YPC Objects to the PR9 Outline proposal documented as 21/03522/OUT

Building Heights

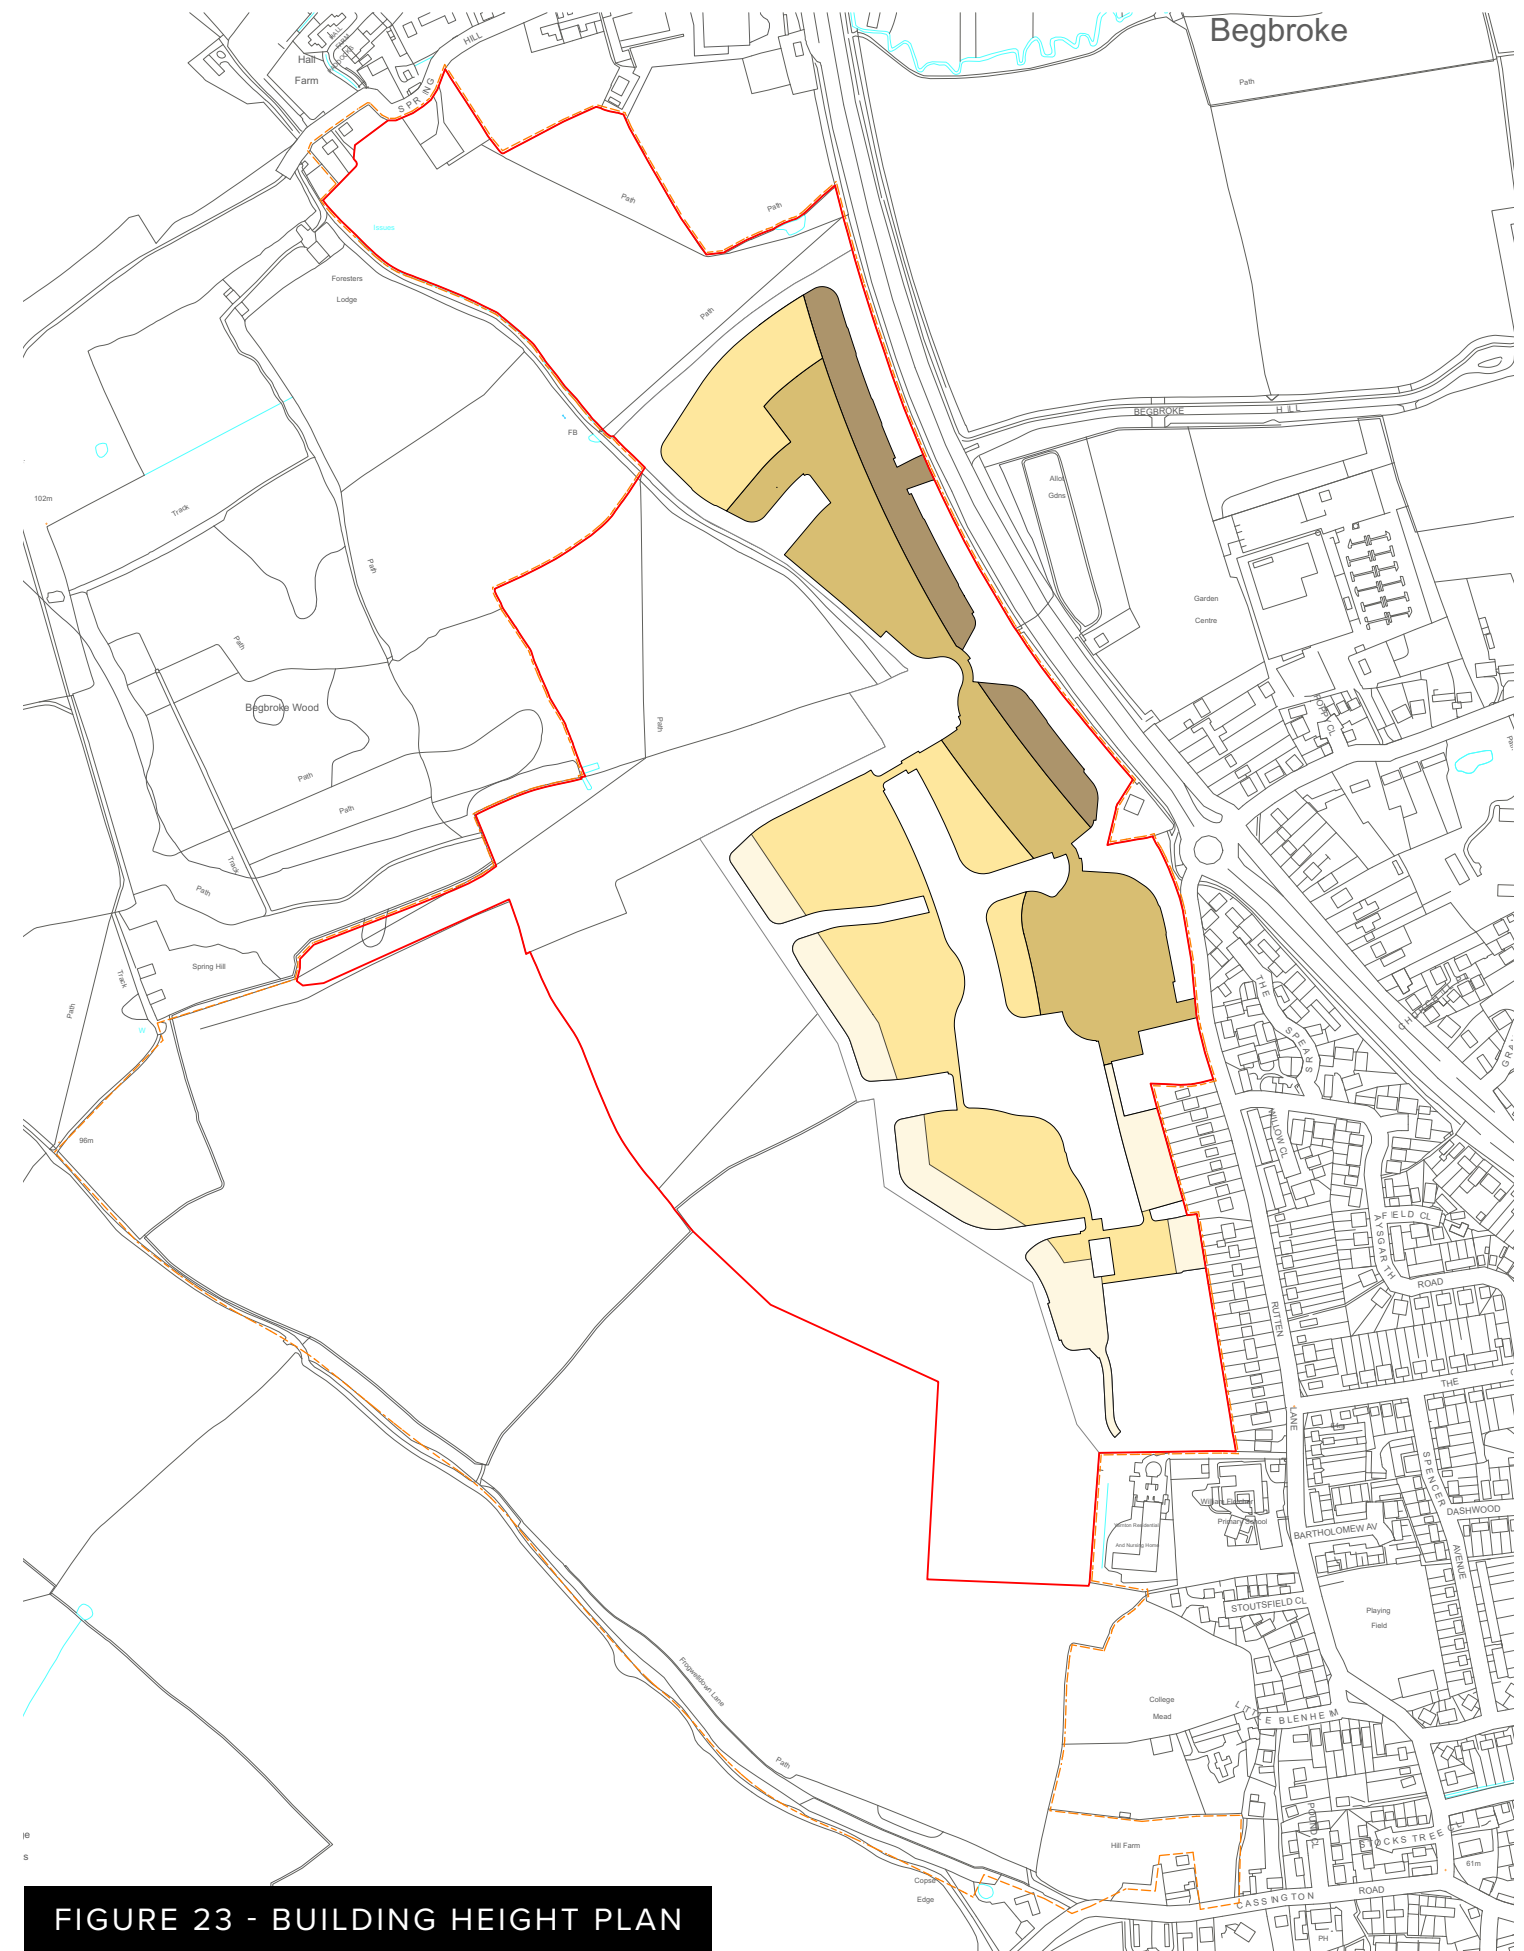
The proposal is described as 'an extension to Yarnton village'. Building design proposals includes those of up to 4 storeys. No other buildings, residential or otherwise, are built to 4 storey height within Yarnton and as such, if permitted, would be out of character with the village and street scene. In addition, since formal proposals for PR8 are outside the scope of this (PR9) proposal and not yet in the public domain it remains a serious concern that if 4 storey dwellings are permitted both sides of the A44 Trunk Road there will be serious negative impact on the rural village aspect, become oppressive and diminish any sense of village continuity.

FIGURE 24 - MOVEMENT PLAN

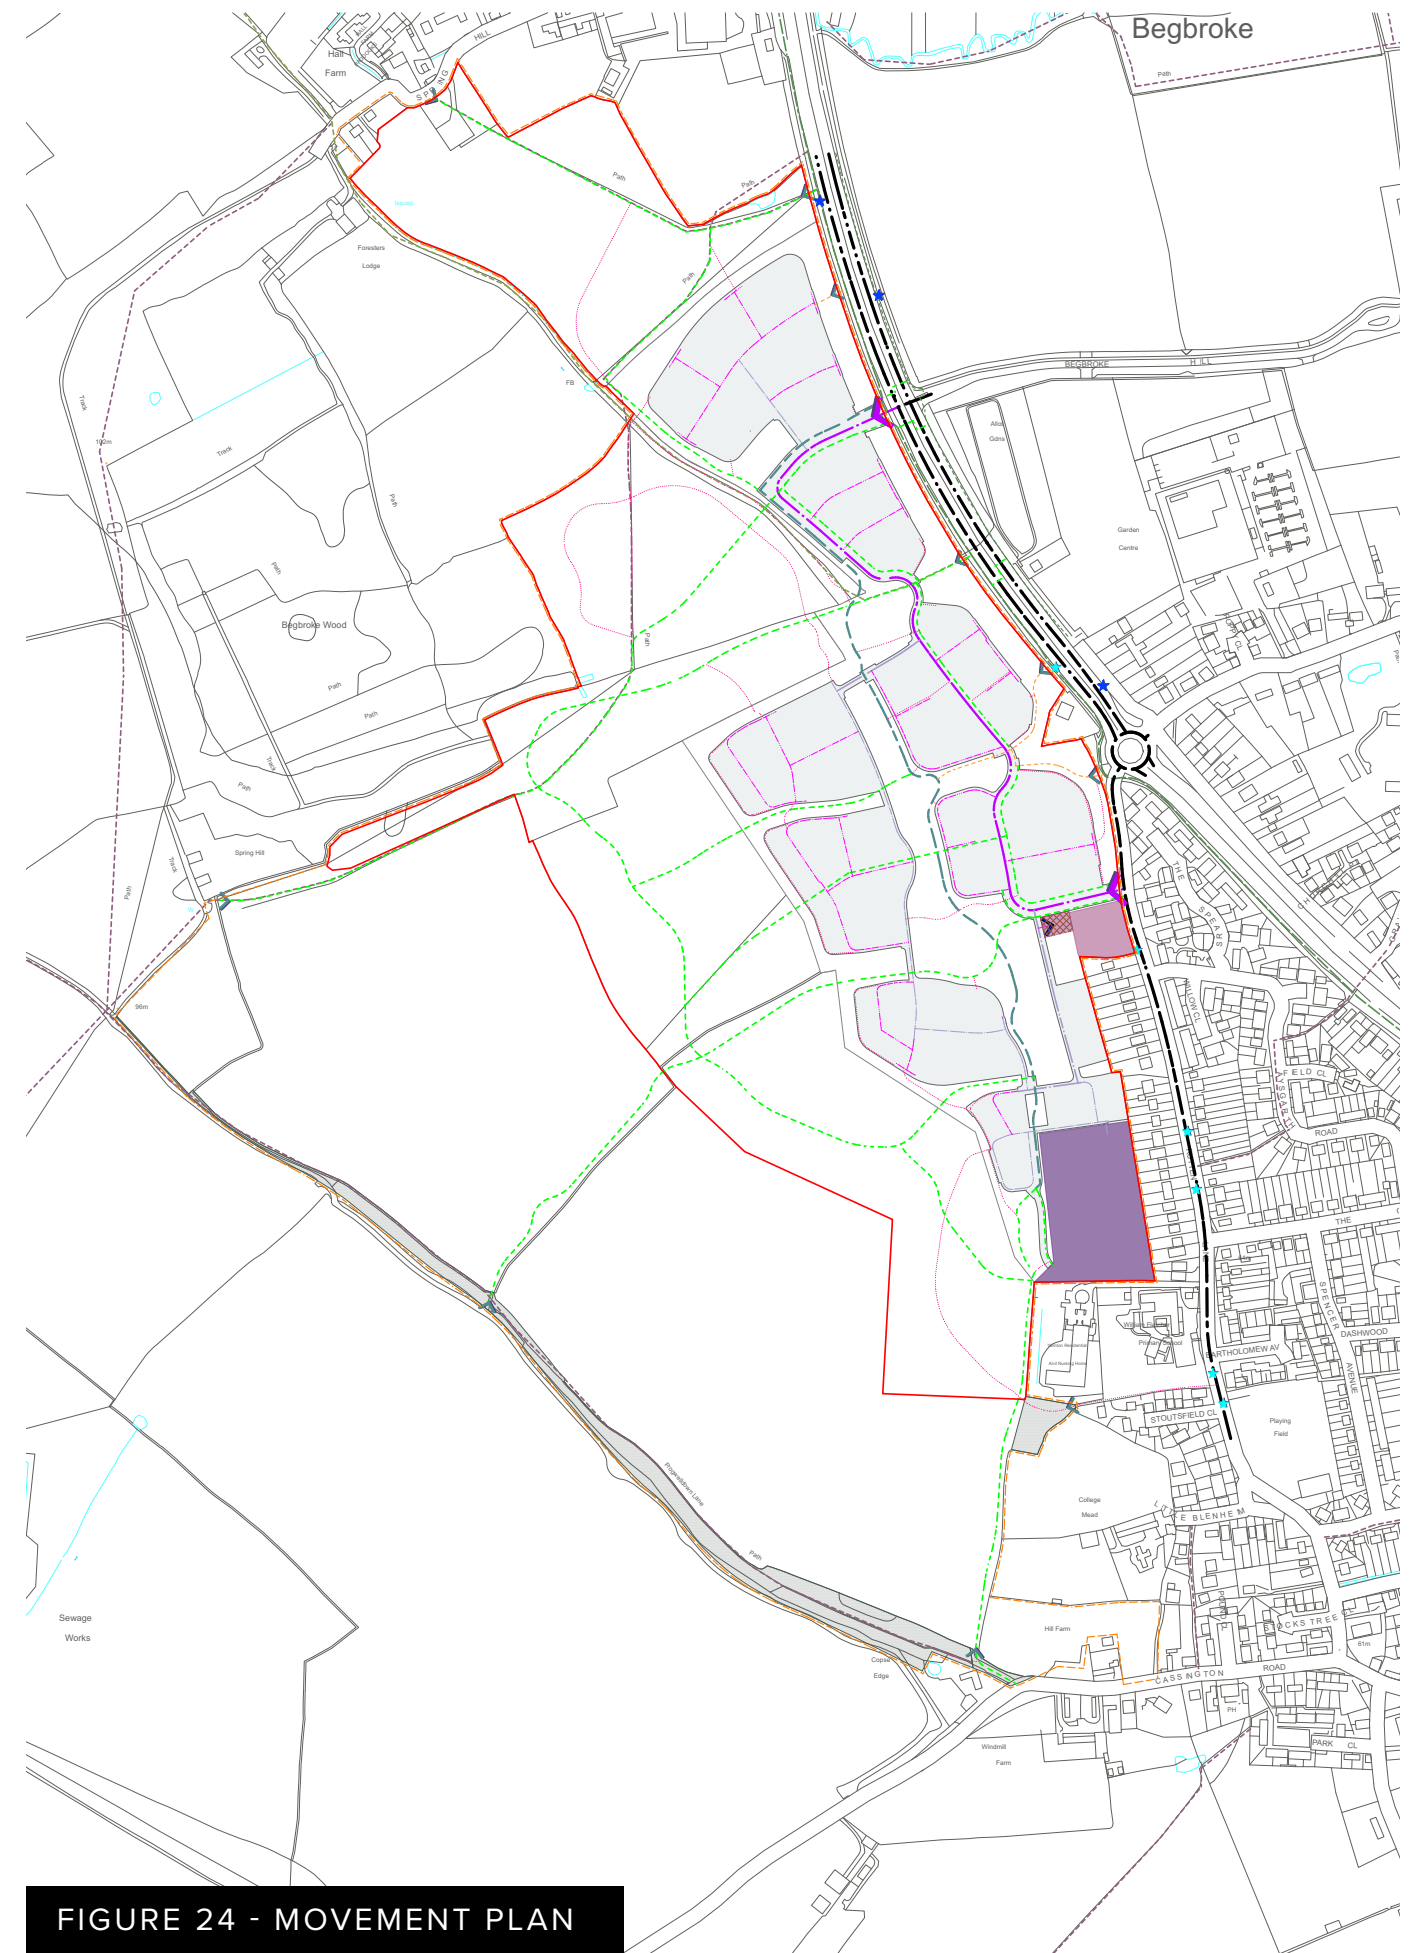
vehicles that will serve the development. Yarnton Parish Council believes that the only safe route onto and off the site will be via the proposed access from the A44. The proposed access from Rutten Lane is unsuitable and risks adverse HGV incidents within the village. Visibility from the proposed Rutten

Lane access is limited and inadequate for safety. SID data show more than 50% of vehicles travel in excess of 30mph at this point. Records above 60mph are recorded. Should Cherwell District Council permit use of access/egress via Rutten Lane during the construction phase it will be seriously disruptive to the atmosphere and work within the adjacent medical practice. In the event that Rutten Lane access is granted, Yarnton Parish Council advises that construction traffic approaches and leaves the site only from/to a northerly direction via the Rutten Lane/Sandy Lane/A44 roundabout. To further prevent inappropriate HGV routing, appropriate vehicle width restriction must be in place in The Garth. Positioned east of the Junction with Aysgarth Road it will allow the support of necessary HGV to properties but obstruct through-traffic with width more than 2.5m. If construction traffic uses the A44 entry then due consideration must be given to the safety of pedestrians and cyclist using the A44 path and cycle lane.
